**Responses to the ExA's Written Questions**  
**ELMESTHORPE PARISH COUNCIL**  
**9<sup>th</sup> January 2024**

Please find below Elmesthorpe Parish Council's responses and/or notes with regard to the Written Questions issued by the Examining Authority on 28<sup>th</sup> November 2023.

#### **1.11.32 Effect on users of Burbage Common Road**

Written Statement of Oral Case ISH2 [Appendix I - Accessibility Plans for Burbage Common Road]

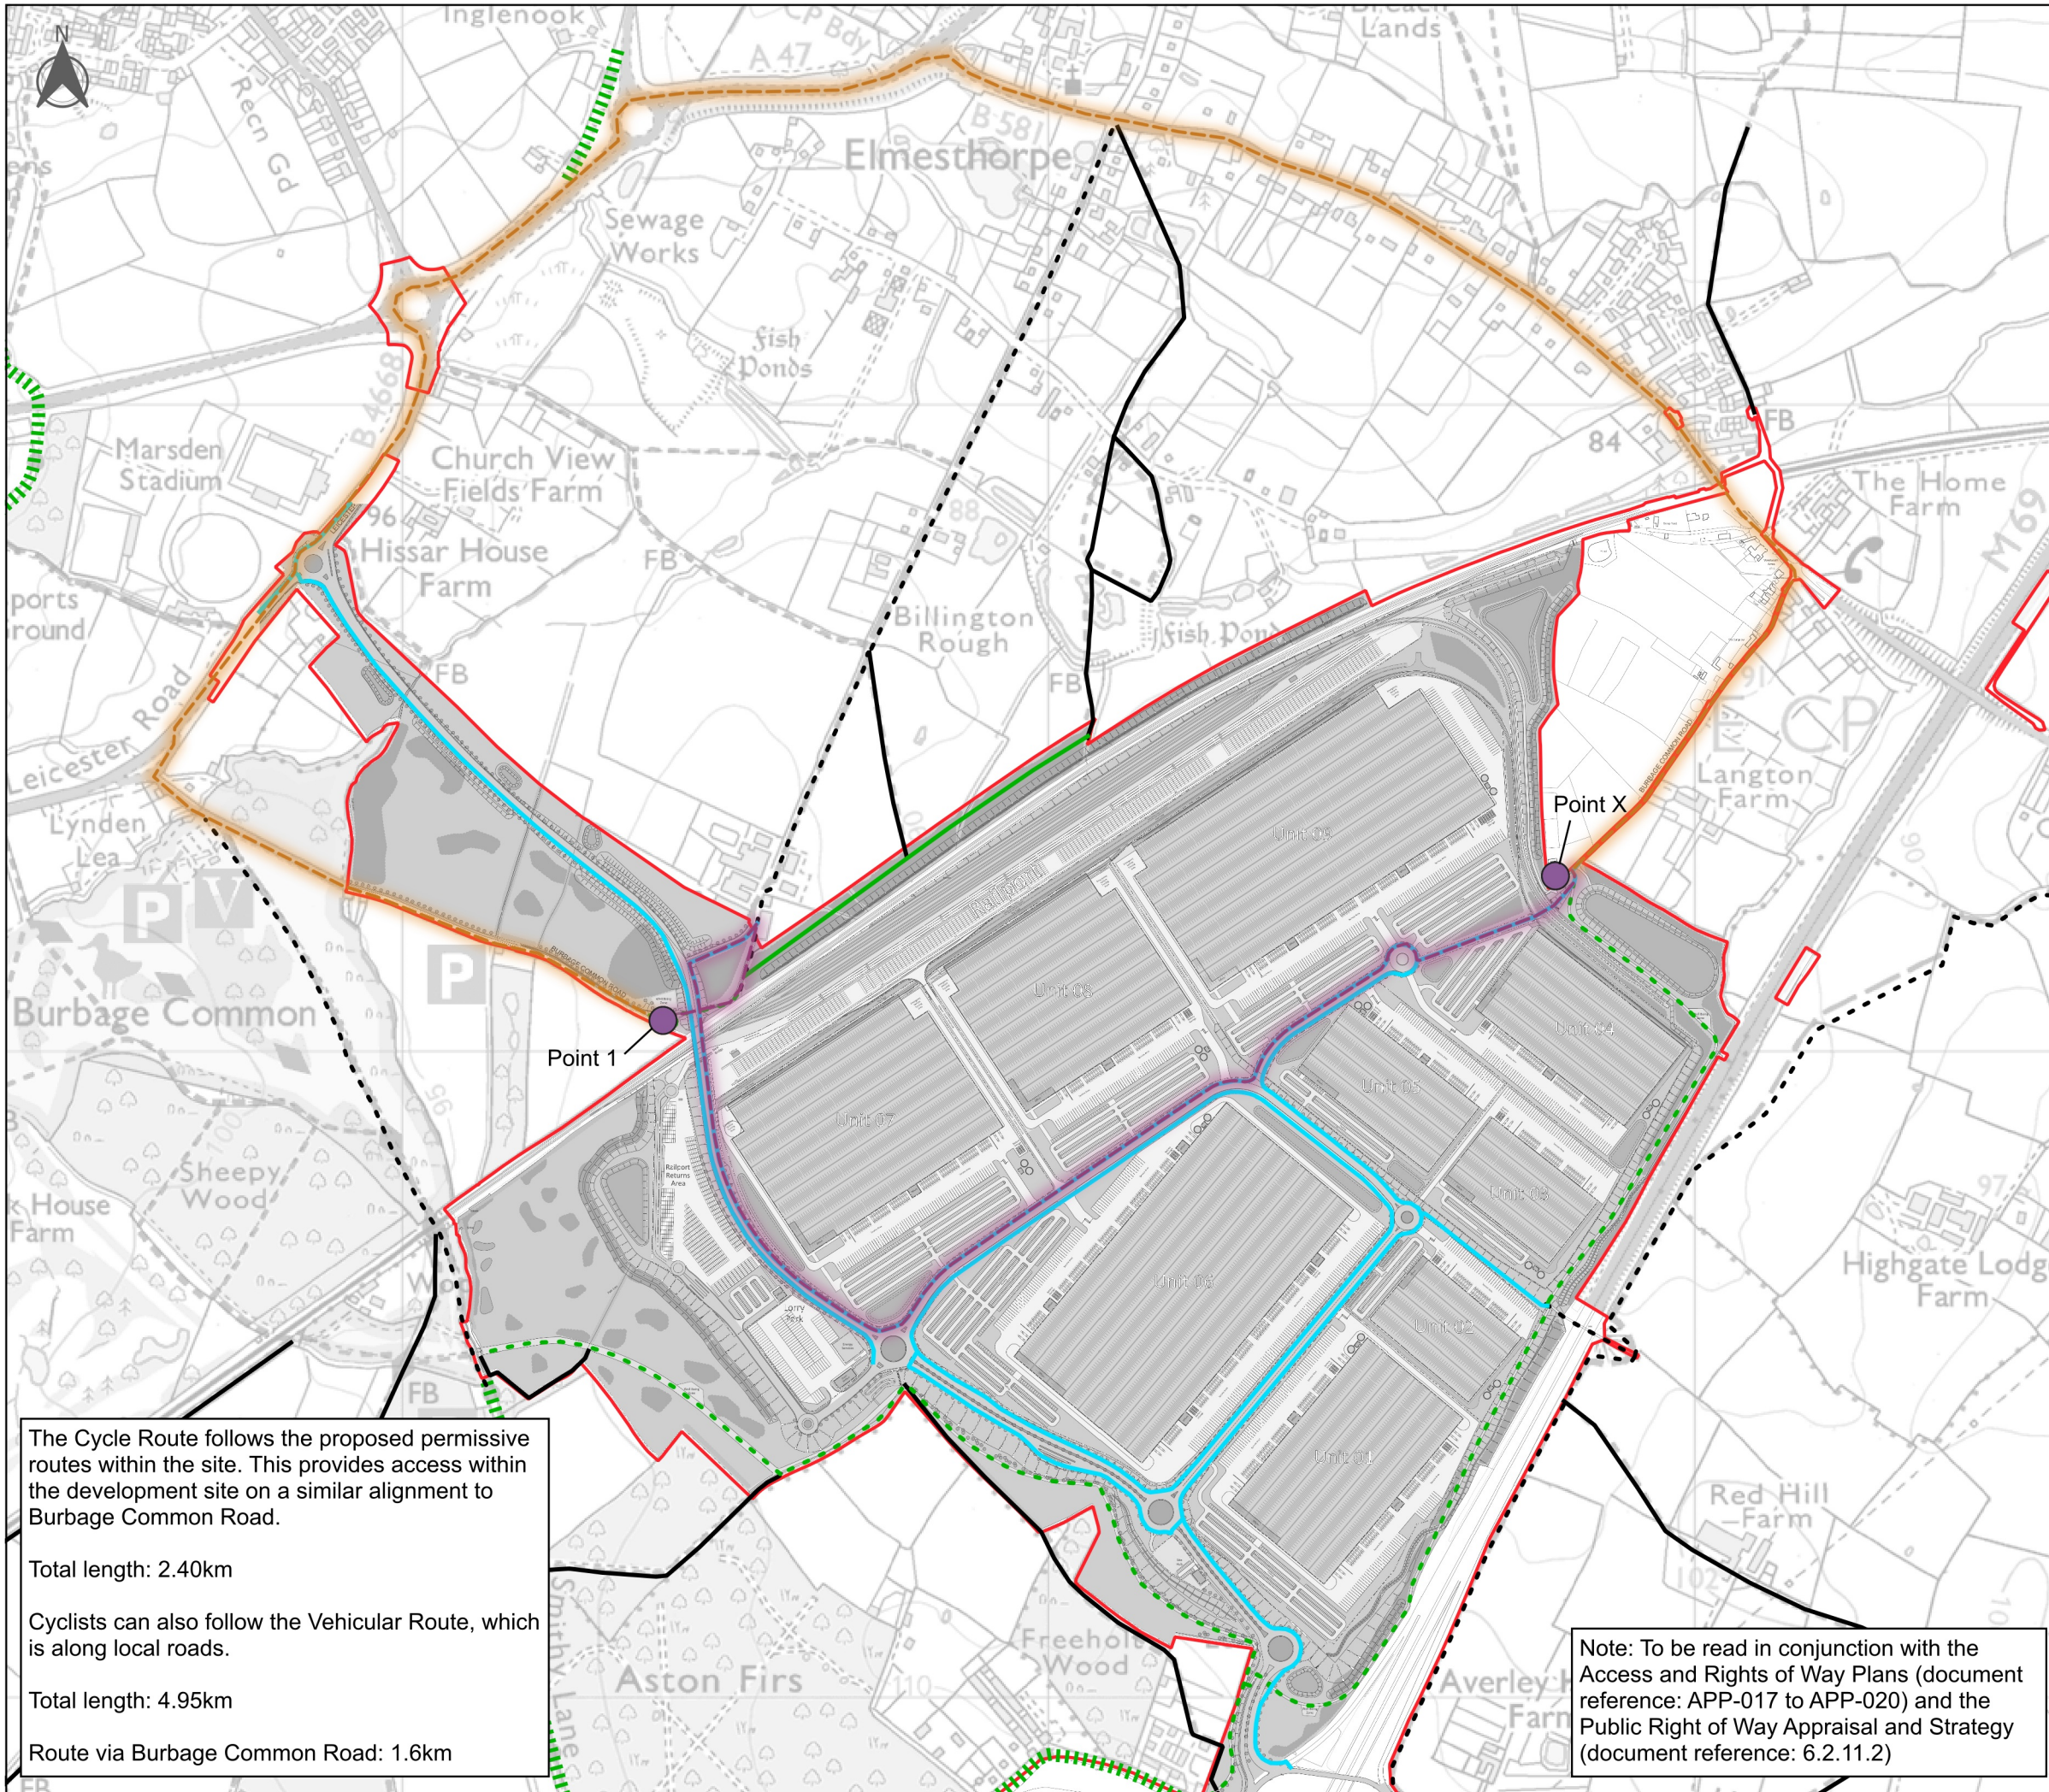
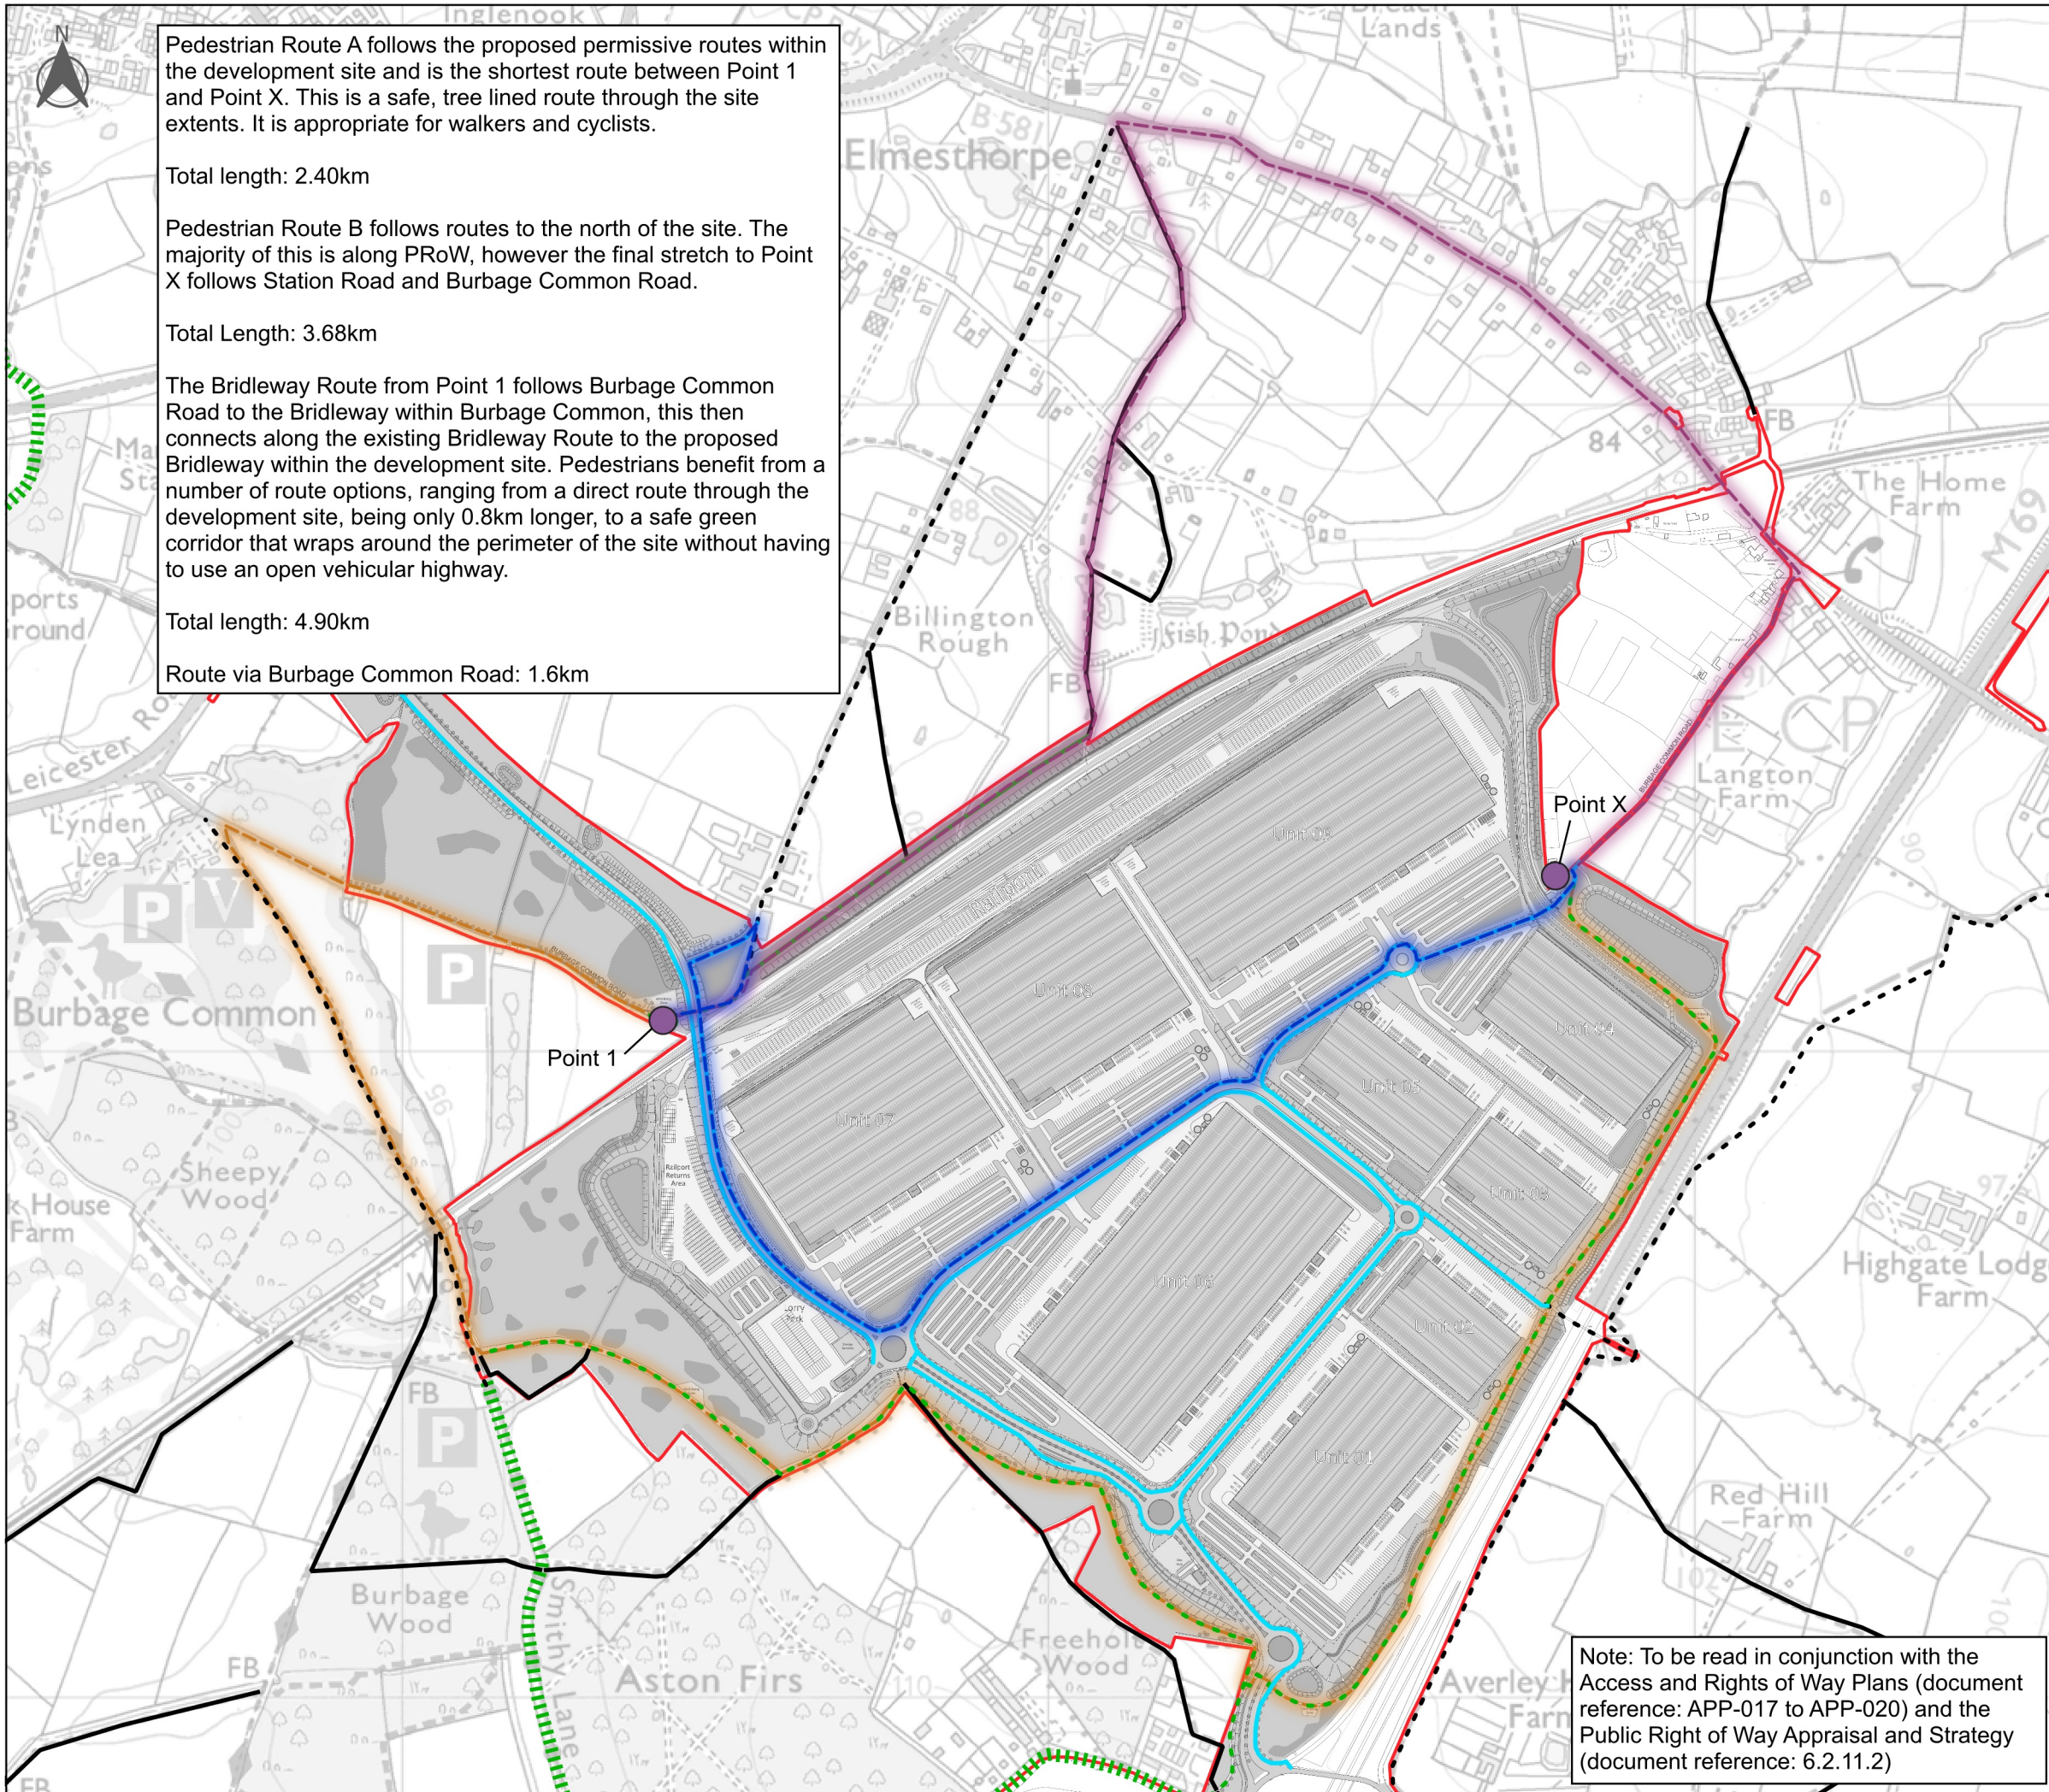
When looking at the distances between point 1 and X on the 'Accessibility Plans for Burbage Common Road', we submit:

Vehicle Users; the current 1.6km route will increase to 4.95km. Our only alternative vehicular access into the village will be entirely removed and any incidents that prevent access from either end of Station Road B581 will severely affect residents and emergency services, and the only available detour will be significant. Add into this the substantial increase in traffic using and joining the B4668 and A47 as a result of the A47 Link road, and the cumulative effect on residents trying to go about their daily lives will be extensive.

Cyclists; The roads surrounding the proposed site are narrow, fast, dangerous and undesirable. Will there be lighting available during the winter months, for those commuting to work (potentially both on and off site) using the revised PRow offered? If so, have the effects of this been considered in the assessments of the impact of lighting on ecology, local residents, energy usage etc? What security will be in place to ensure safety at the newly installed underpasses? Cyclists travelling through the site from Elmesthorpe will not be exiting onto the M69 and therefore will be joining the main carriageway at the roundabout where the A47 link road meets the B4668. What provisions will be made to protect cyclists at this busy junction, mainly occupied by HGVs?

Bridleway Users: the current 1.6km route will increase to 4.95km. Aside from the substantial increase in distance which not only will tire the horse out before they even reach their destination; the additional time implications involved in this impacts the frequency that equestrian users may be able to hack in their own locality. This is removing a key benefit and reason that many equestrian business and private owners chose to base themselves here for. It goes without saying that the amenity of the new bridlepath provided is no substitute for the environment currently experienced.

Walkers: It is firstly considered the user group merely identified as 'Walkers' is a very broad group and doesn't identify the many different types of users who use this area as pedestrians. That aside, walkers who use the current 1.6km PRow route experience a wide, level, quiet road that serves more as a path enjoyed by all types of people and animals, with immediate access to the amenity of surrounding countryside. It does not discriminate against any groups whom fall within the groups identified with Protected Characteristics and provides unimpeded access for all, should they choose. All of the proposed alternative PRows for pedestrians provide increased distances (the shortest increase being a full 50% increase) which will serve to alienate and exclude some users, including (but not limited to) those who currently walk with young children to utilise the newly upgraded children's play area at Burbage Common or those with mobility issues. All of the proposed alternative routes offer reduced amenity and experience to the current PRow and nobody would choose to simply take a shorter leisurely amble around a SRFI before returning home due to personal limitations. The increase in route distances, and the stark reduction in amenity value would entirely remove the access to countryside for some users.
